FIVE ESTUARIES OFFSHORE WIND FARM

10.26 APPLICANT'S COMMENTS ON DEADLINE 2 SUBMISSIONS

Application Reference:	EN010115
Document Number:	10.26
Revision:	A
Pursuant to:	Deadline 3
Eco-Doc Number:	005430912-01
Date:	November 2024

Figure 12.1 Protocol for Archaeological Discoveries

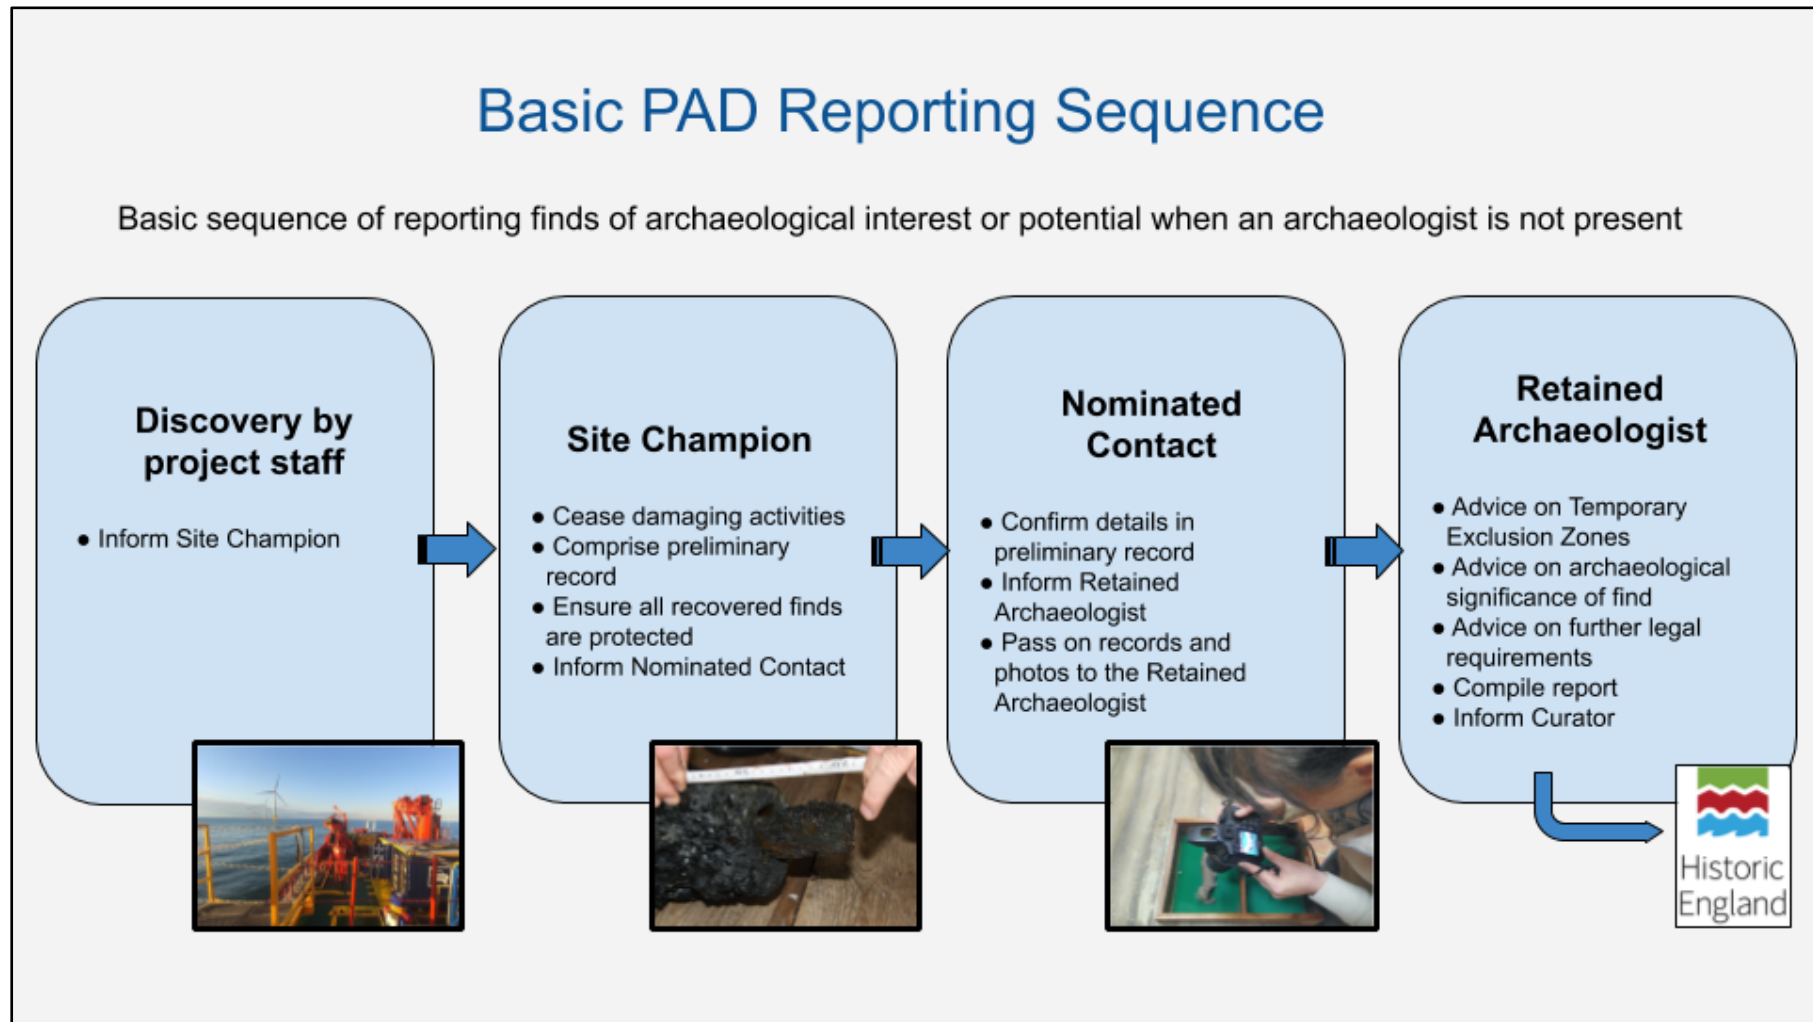
HE1.41	Section 6.7.33 outlines the PAD that will be implemented to record any unexpected archaeological discoveries. We would recommend that a robust training programme is provided to the project staff to ensure that they are aware of the sort of materials/remains that may be discovered and what they can look like.	Noted by the Applicant, The Applicant also refers to Appendix A outline project-specific protocol for archaeological discoveries (PAD).
HE1.42	Section 7.1.6 - we do not agree that the Applicant "may" engage one or more archaeological contractors to deliver the mitigation measures set out within this Outline Marine WSI. It will be a condition of any DCO secured for this project that a Retain Archaeological Advice service (professional, accredited and experienced as we advised in our response to the PEIR consultation) will take the Outline WSI and, in consultation with Historic England (and local curatorial service where relevant), as described in section 9.1.1 and 9.1.2, produce a project specific WSI for agreement with the relevant competent authority.	<p>No change. As stated in section 7.1.6 The Applicant will engage a Retained Archaeologist to implement the final Agreed WSI but may also engage archaeological contractors for specific work packages outside the expertise and/or capacity of that archaeologist for delivery of specific work packages.</p> <p>This approach is reflected also on page 11 within the guidance document Archaeological Written Schemes of Investigation for Offshore Wind Farm Projects (The Crown Estate, 2021).</p>
